Suffolk & Essex Coast & Heaths National Landscape Partnership response to ExA Q1 issued 17 December 2025

Question: National Landscape (NL) duty

Suffolk & Essex Coast & Heaths National Landscape Partnership for Deadline 2

- *REP1-130 Suffolk County Council Local Impact Report*
- *REP1-120 Volume 9.47 National Landscape Section 85 Duty Technical Note*

**Plate 3.2 Preferred area of acid grassland enhancement**

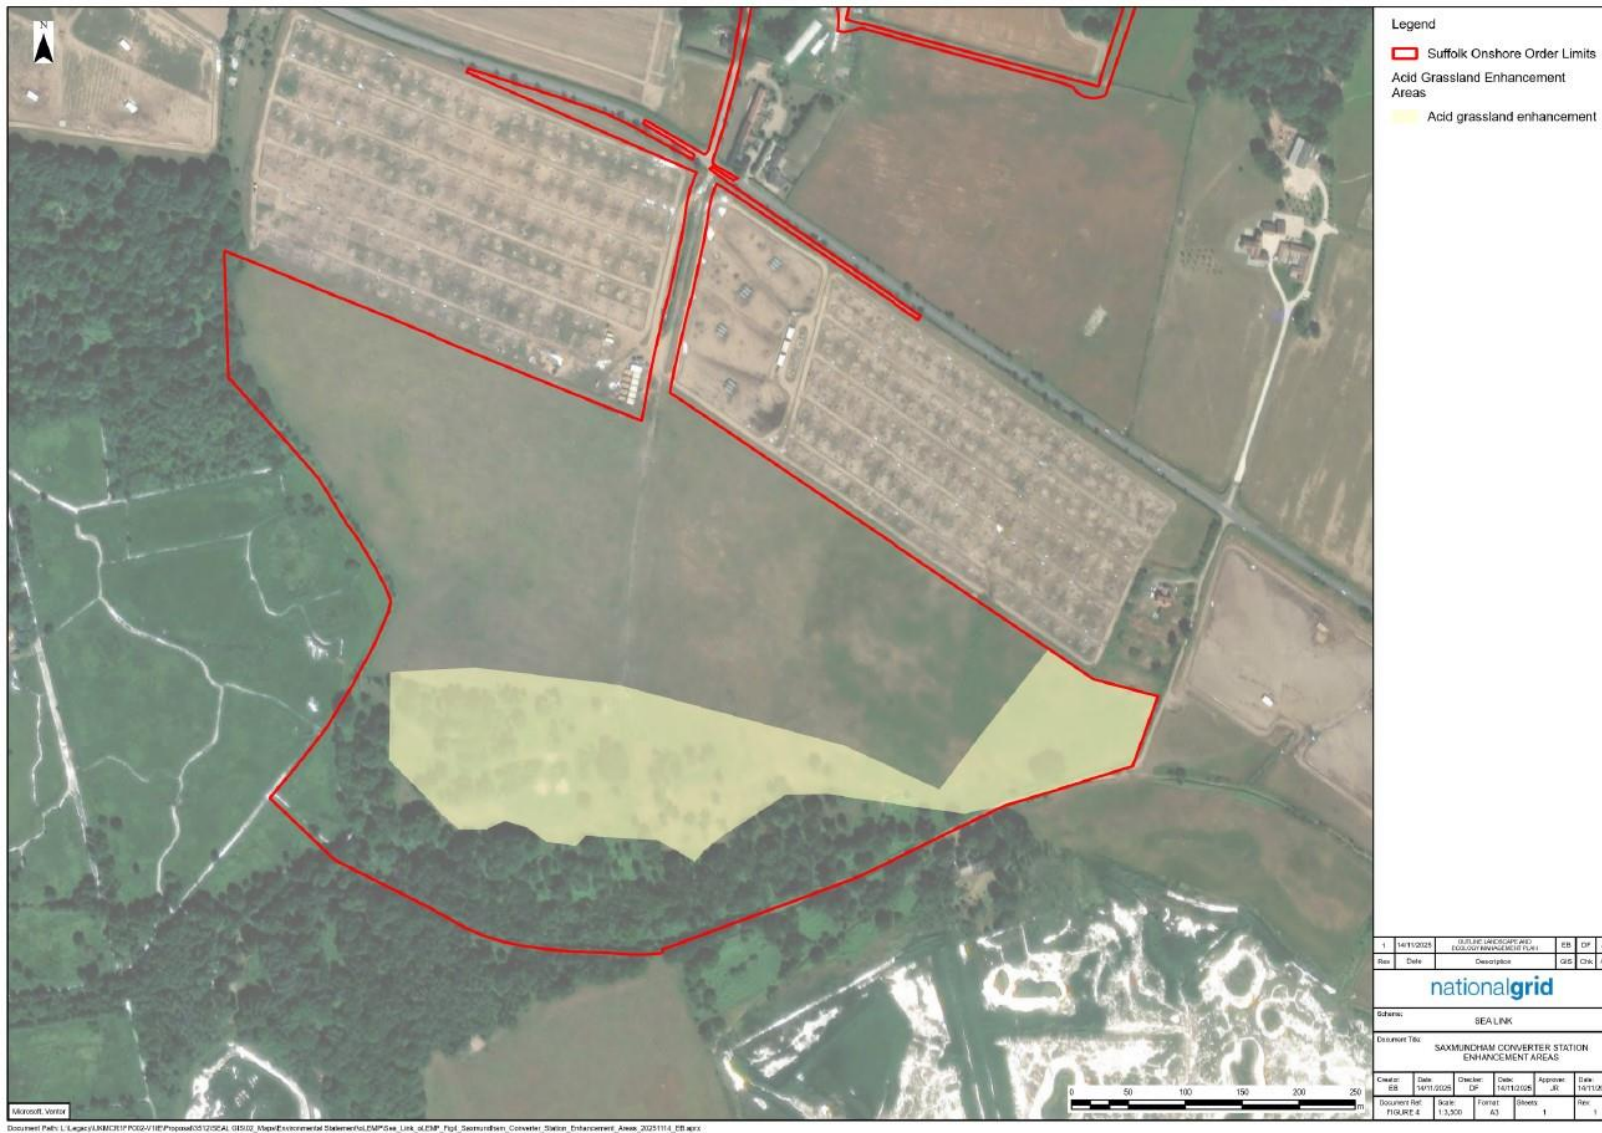
In your response include consideration of whether the extent and nature of the preferred area of acid grassland on plate 3.2 of [REP1-120] is sufficient and the appropriateness of the maintenance period of 10 years.

A key concern relates to the fact that only enhancement, rather than creation, of acid grassland is now proposed as indicated in paragraph 3.2.3. This means that there won’t be any increase in the area of acid grassland to offset its reduction during construction. The proposal is therefore less robust as an offsetting measure as it does not rectify the temporary decrease in acid grassland provision hence, there will be no remedy for acid grassland loss for a substantial period, with restoration of acid grassland removed during construction projected to be completed by Q3 of Year 6. By consequence, net-enhancement of acid grassland is projected to only last 4.25 years due to the 10-year maintenance period.

Whilst there is potential for the enhancement of acid grassland to persist beyond the 10-year maintenance period, it is problematic to rely upon this notion in relation to discharging the duty. The Applicant will not have land rights to the area after 10 years meaning the previous landowner would be within their rights to remove or otherwise undermine the enhanced acid grassland. In any case, the quality of the enhancement would begin to deteriorate once the maintenance period is over and the rate of deterioration is not known at this stage.

Consideration should be given to how the proposed measure will be experienced by people interacting with the natural beauty of the National Landscape. The proposed parcel of land is located within a farmer's field surrounded by shrubbery. Whilst a PRoW is adjacent to the parcel of land, it is relatively tucked away from users of the National Landscape and certainly more so than the bulk of works adversely affecting the National Landscape. The extent to which users of the National Landscape will actually experience enhanced natural beauty in comparison to the extent to which this experience will be adversely affected by the proposed development does not appear to have been considered. It is possible that a different parcel of land, or a different type of measure, would be more noticeable to users of the National Landscape even if the extent to which natural beauty itself is enhanced remains unchanged.
